Application for approval of details reserved by condition.
Town and Country Planning Act 1990
Planning (Listed Buildings and Conservation Areas) Act 1990

9 No. dwellings with associated car parking, bin storage & landscaping & creation of new access road from existing access onto West Walberton Lane. This application is a Departure from the Development Plan.

Planning Ref: WA/75/17/PL

Amended layout plan showing a change of orientation of pond and details of amended headwalls and wingwalls.

Drawing Status	AS BUILT
Client	Driftstone Developments Ltd.
Project	Sunny Corner, Walberton West Sussex BN18 0QS
Drawing Title	Engineering Layout - Below Ground Drainage
Scale	1:250
Date	Jul. '21
Drawn By	DJL
Checked By	MJA
Drawing No.	D1833-002
Rev.	K

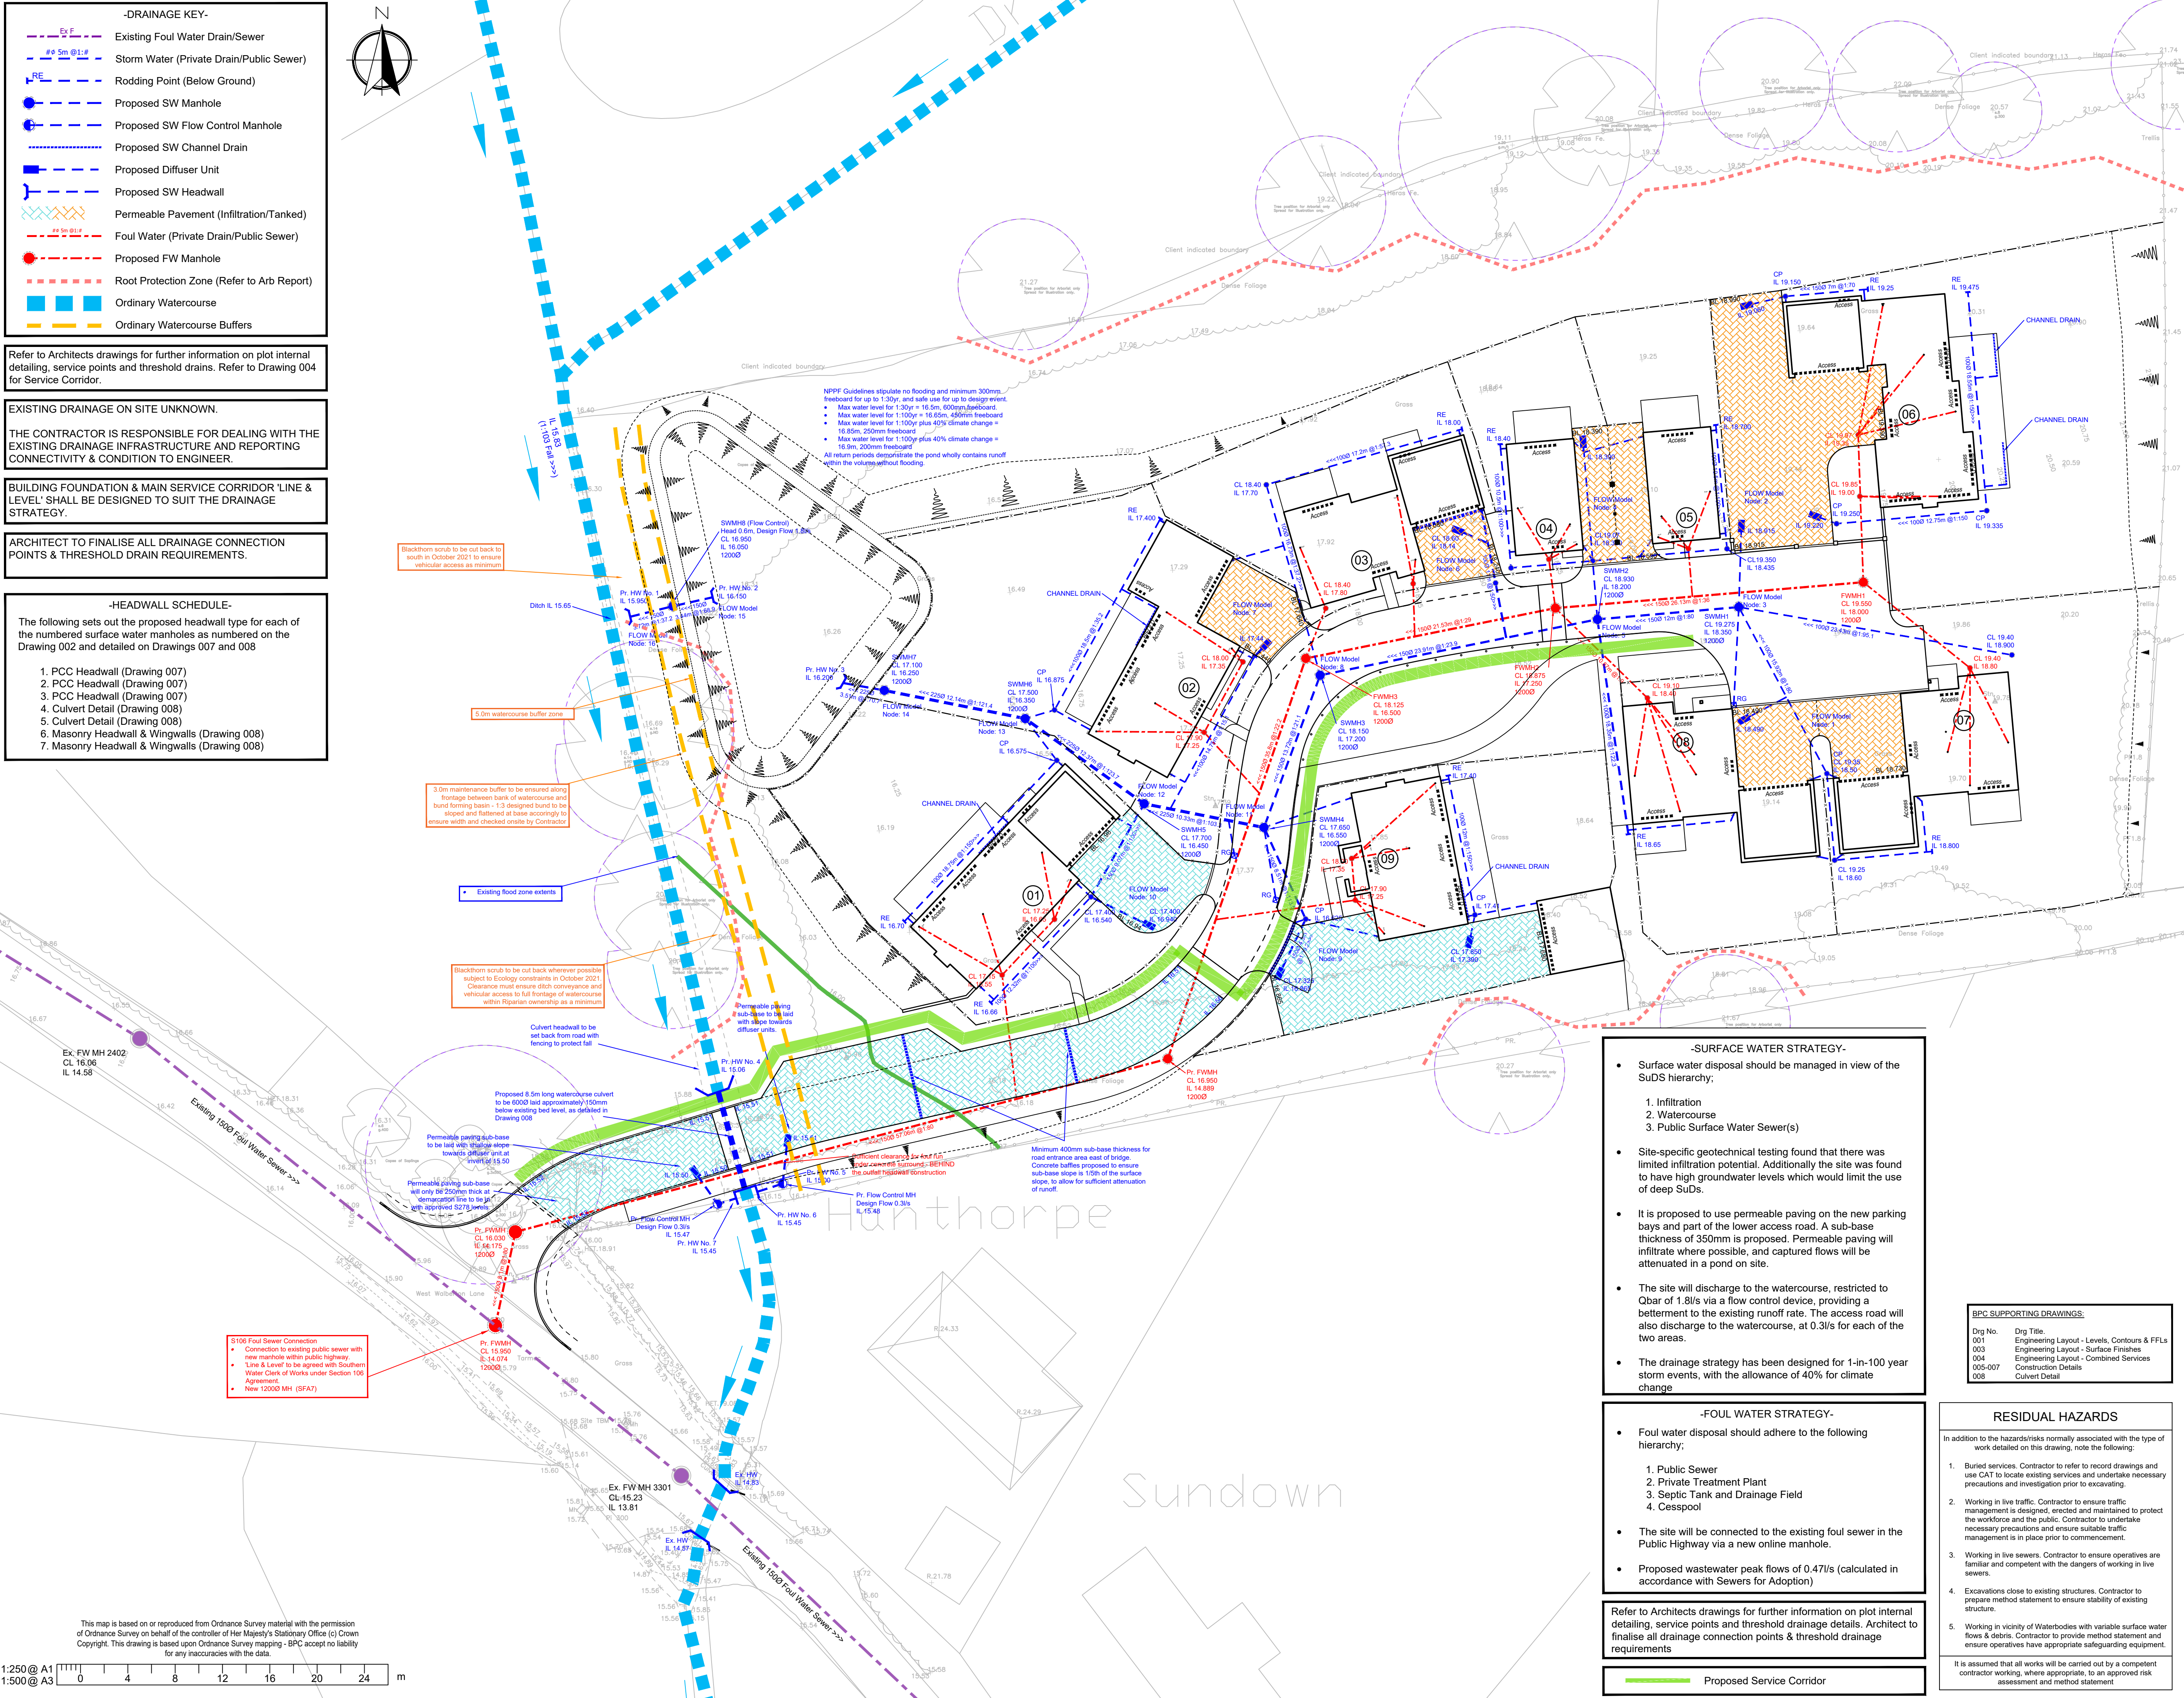
Please update the headwall schedule on the layout plan ie. headwalls 6 & 7.

Regarding the suds pond re-orientation, this is likely to need to go back through Planning approval process (no evidence to suggest it has). I have copied in the planning officer in this respect.
